LDC COMMENT RESPONSES 11-04-19  
 David V. Hostetler - DVH  
 dhostetler@ldc-inc.com (719) 528-6133

SITE DEVELOPMENT PLAN  
1755 E. LAS VEGAS STREET, COLORADO SPRINGS, EL PASO COUNTY, COLORADO

**ROCKY TOP RESOURCES**  
**SITE DEVELOPMENT PLAN**  
PORTIONS OF THE EAST HALF OF THE NORTHEAST QUARTER OF SECTION 29 AND THE WEST HALF OF SECTION 28, TOWNSHIP 14 SOUTH, RANGE 66 WEST OF THE 6TH P.M., EL PASO COUNTY, COLORADO

SITE DEVELOPMENT PLAN

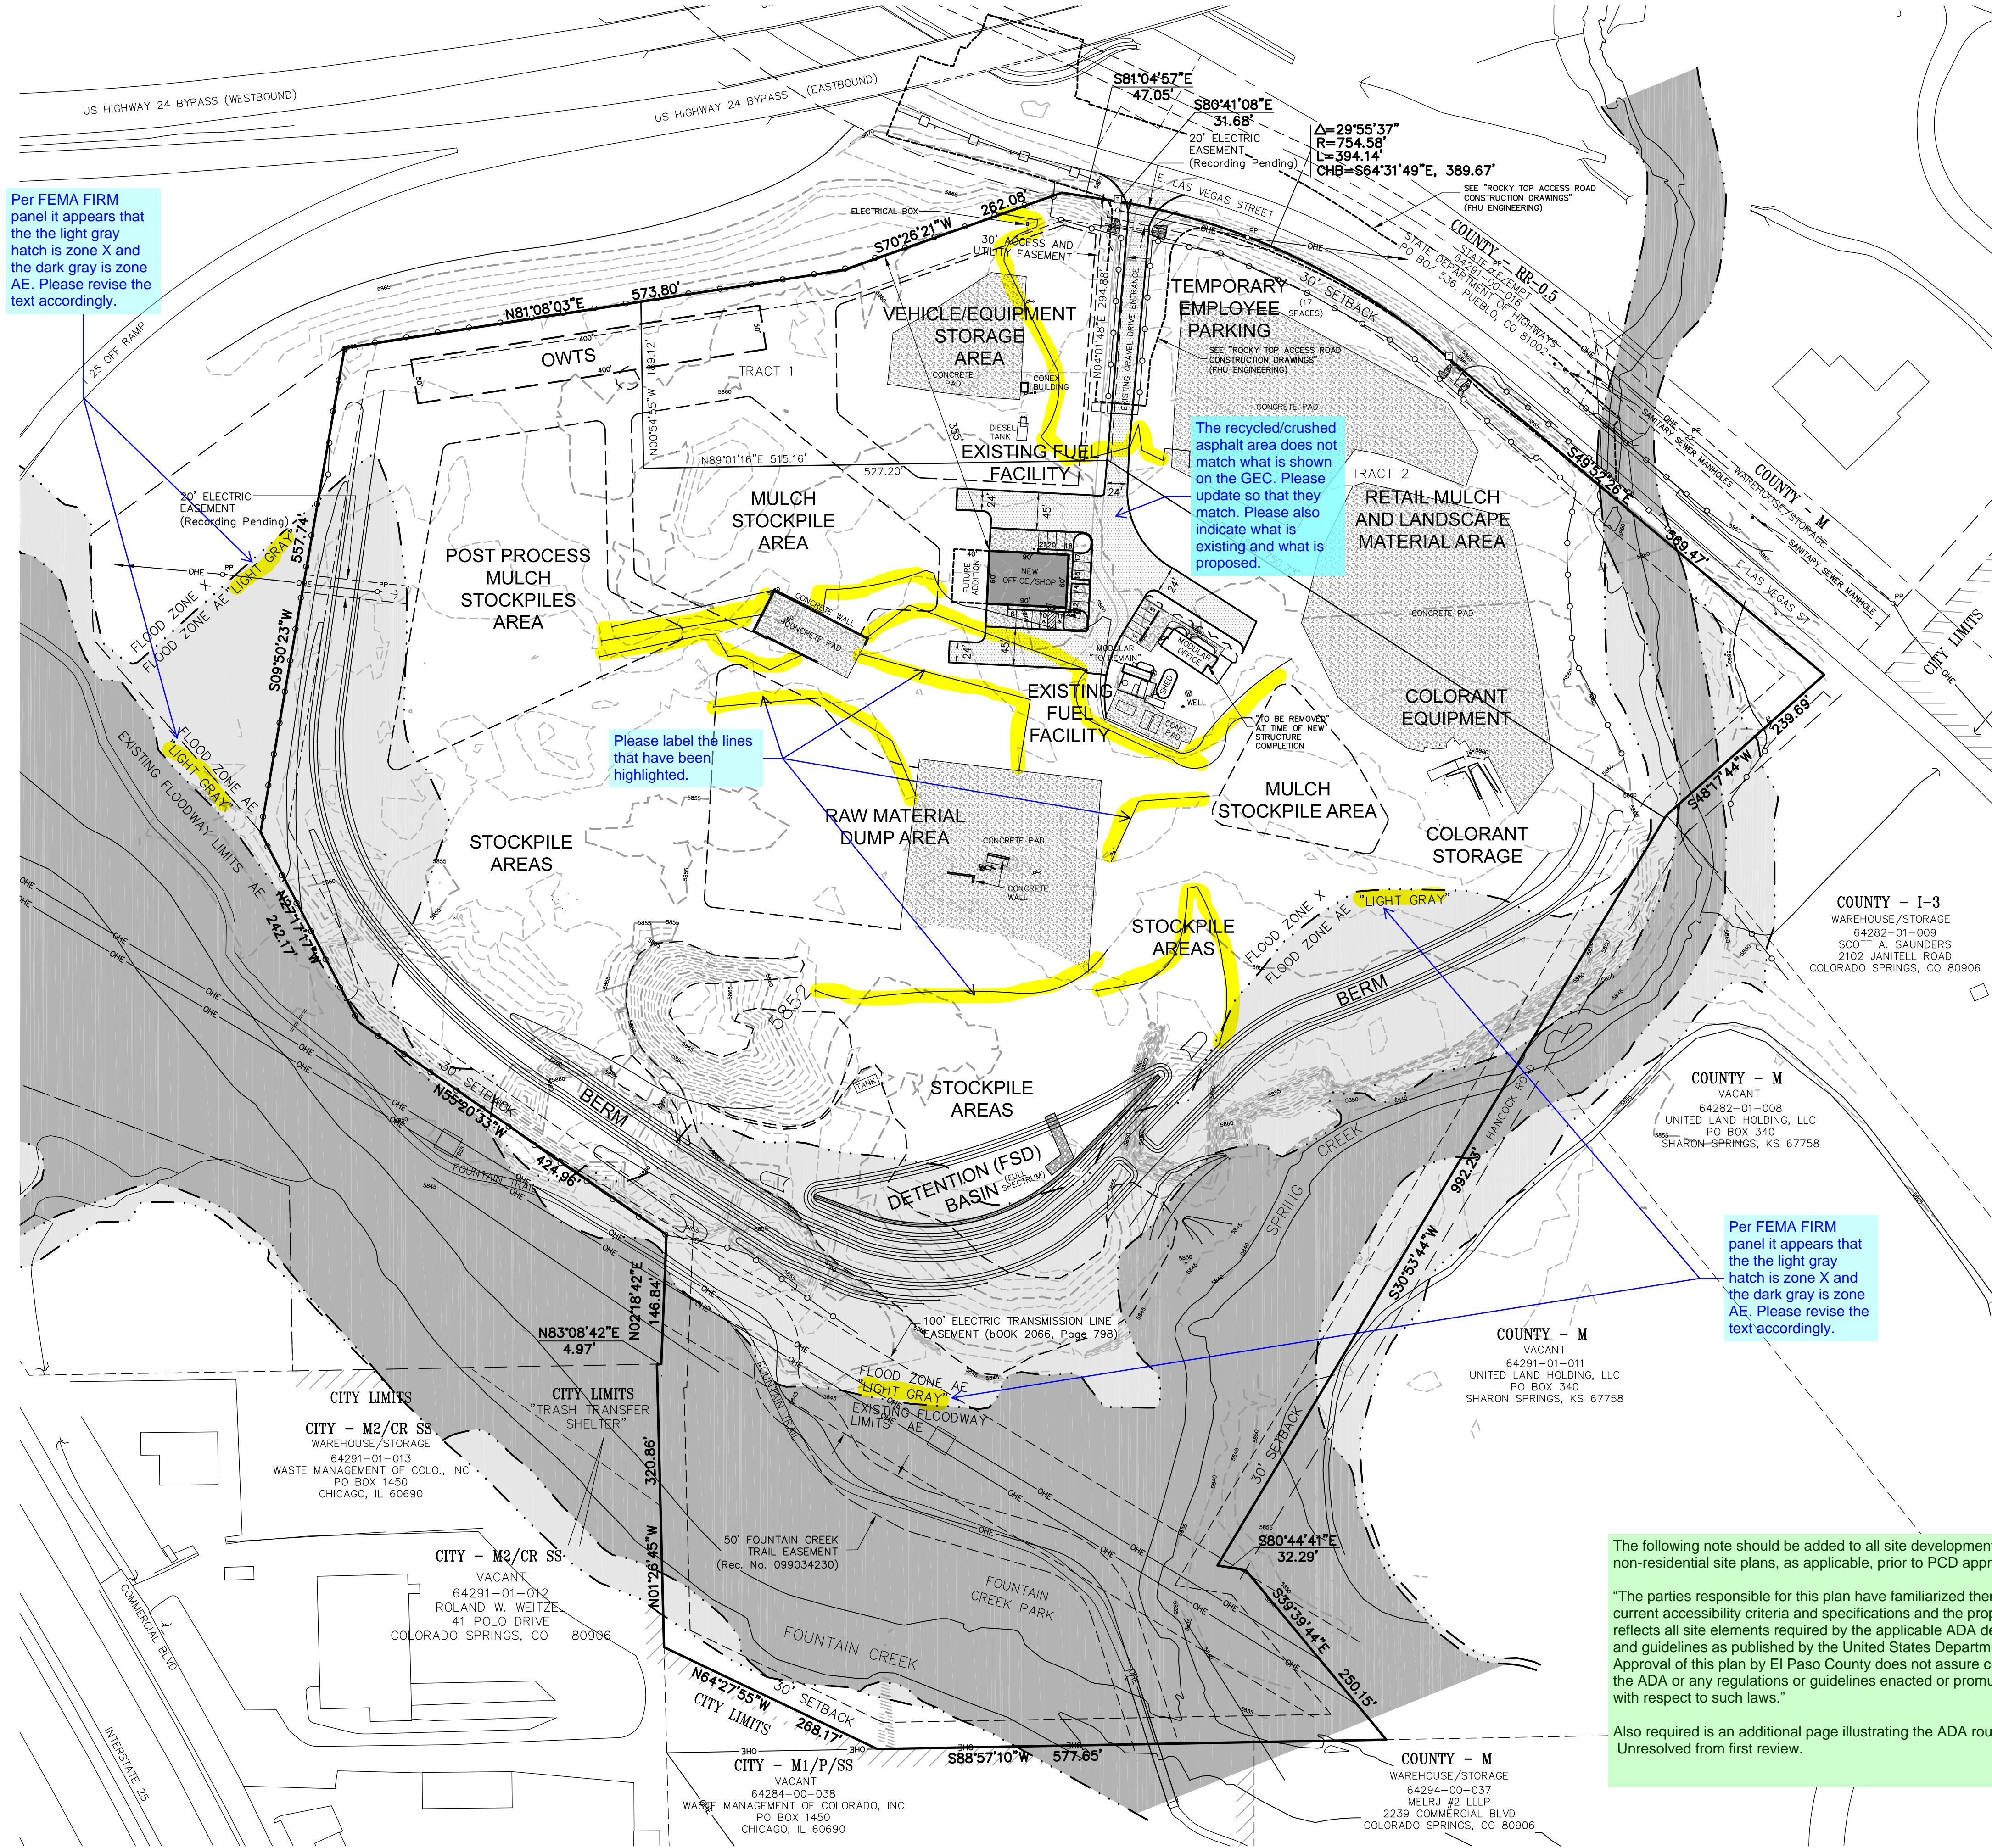
Per FEMA FIRM panel it appears that the the light gray hatch is zone X and the dark gray is zone AE. Please revise the text accordingly. **REVISED - DVH**

Please label the lines that have been highlighted. **LABELED - DVH**

The recycled/crushed asphalt area does not match what is shown on the GEC. Please update so that they match. Please also indicate what is existing and what is proposed. **MATCHES NOW AND INDICATED IN LEGEND - DVH**

Per FEMA FIRM panel it appears that the the light gray hatch is zone X and the dark gray is zone AE. Please revise the text accordingly.

**REVISED - DVH**

**LABELED - DVH**

The following note should be added to all site development plans or non-residential site plans, as applicable, prior to PCD approval:

"The parties responsible for this plan have familiarized themselves with all current accessibility criteria and specifications and the proposed plan reflects all site elements required by the applicable ADA design standards and guidelines as published by the United States Department of Justice. Approval of this plan by El Paso County does not assure compliance with the ADA or any regulations or guidelines enacted or promulgated under or with respect to such laws."

Also required is an additional page illustrating the ADA route.  
 Unresolved from first review.

ADDED ON SHEET 1 OF 1 - DVH
